## National Highways Planning Response (NHPR 21-09) Formal Recommendation to an Application for Planning Permission

### **Council's Reference: 21/03267/OUT**

**Location:** OS Parcel 0006, southeast of Baynards House Adjoining A43, Baynards Green

### **National Highways Ref: 92857**

BOUNDARY SECTIONS 11-15

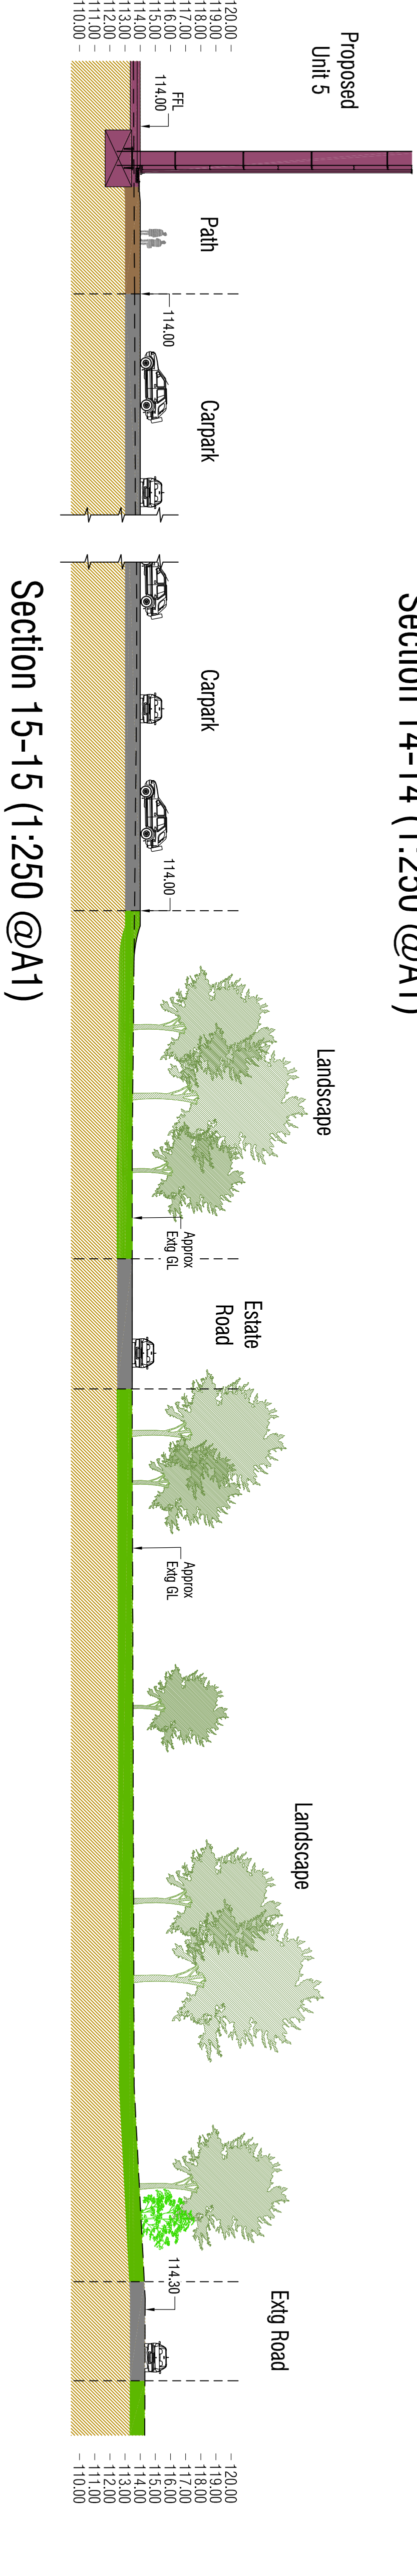
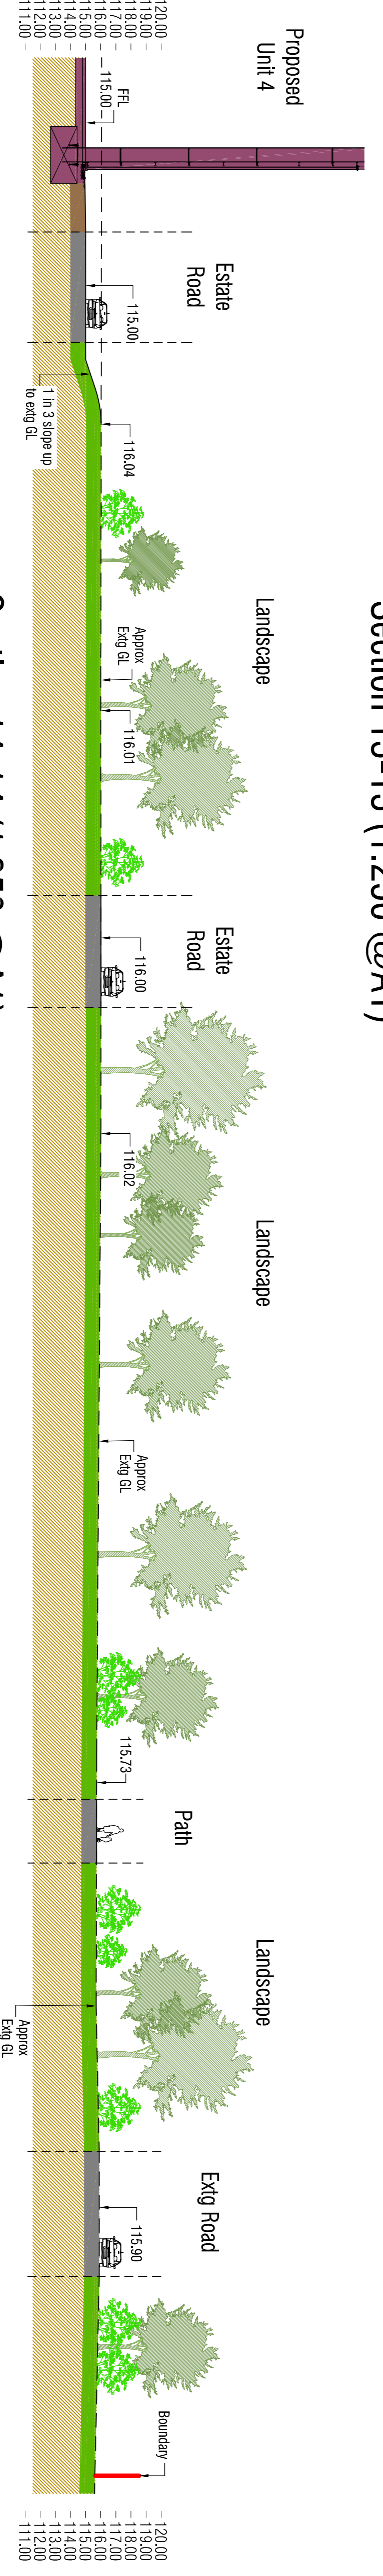
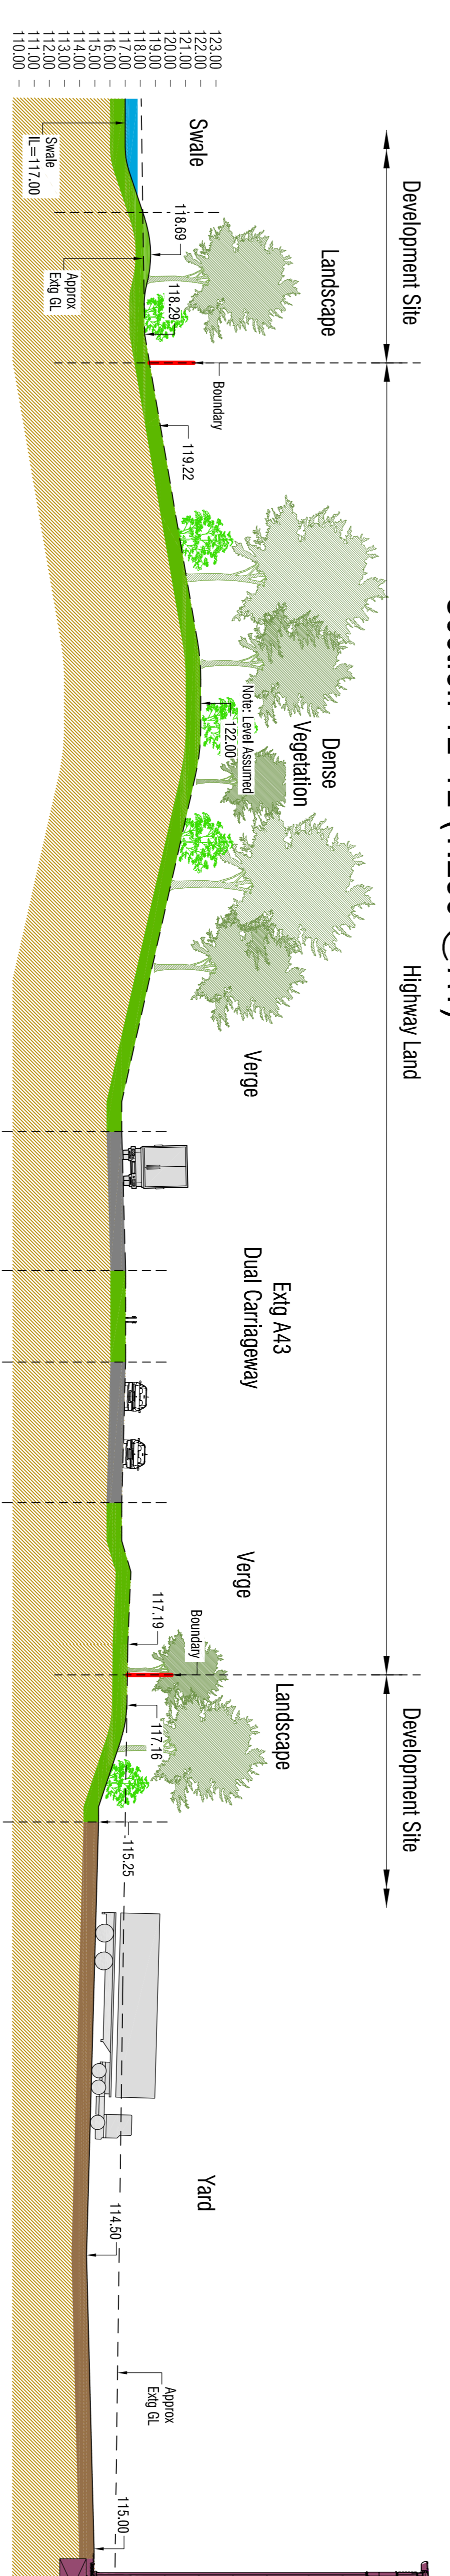
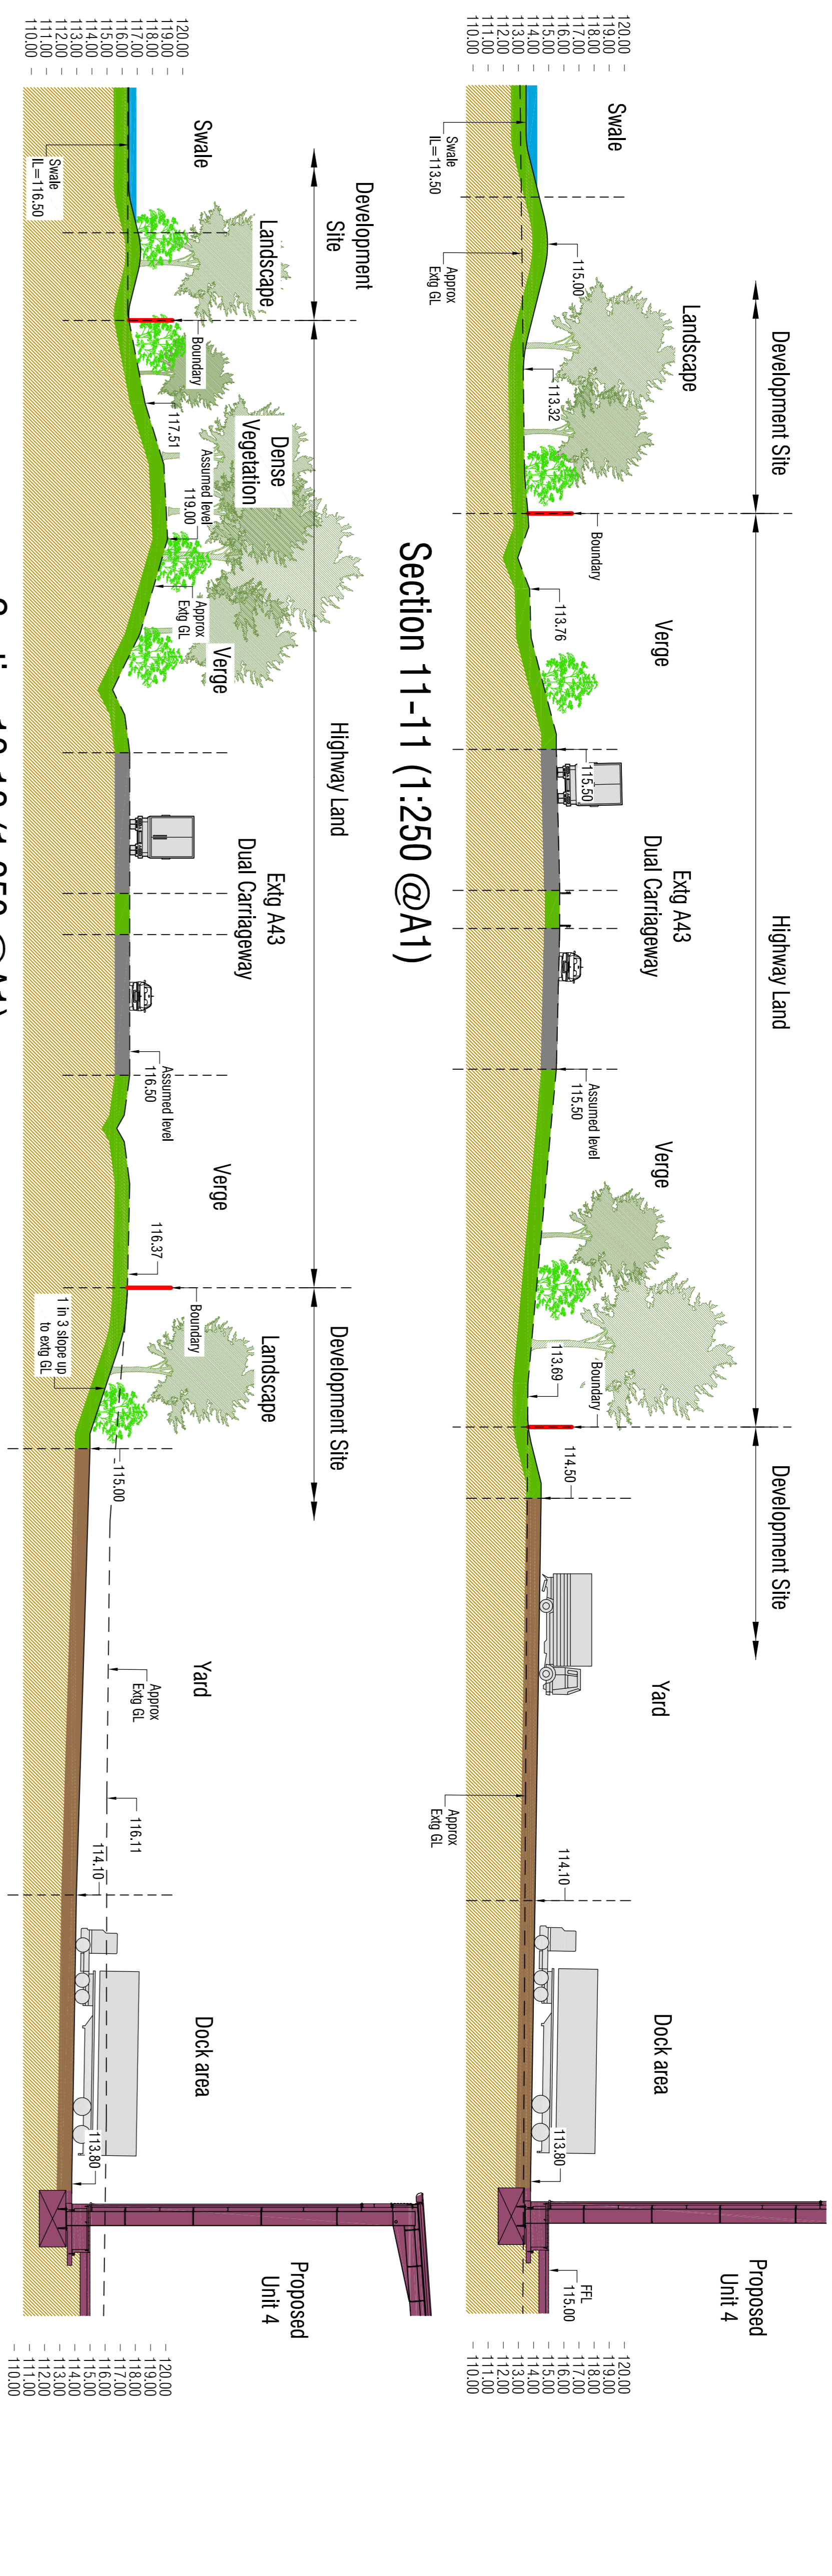
The applicant will need to advise / confirm if there will be any earthworks associated with the development(s) in relatively close proximity to National Highways boundaries (e.g. the stability of the balancing ponds, etc). In the first instance, some cross sections (to scale) through the boundaries showing the proposed extent of the development, its features and any proposed changes in elevation (excavations, landscaping) etc should be submitted for further assessment. Once received, we will review to determine the possible extent of any geotechnical reporting under the Design Manual for Roads and Bridges (DMRB) standard CD 622, which may be required to confirm the extent of any geotechnical risk to the SRN.
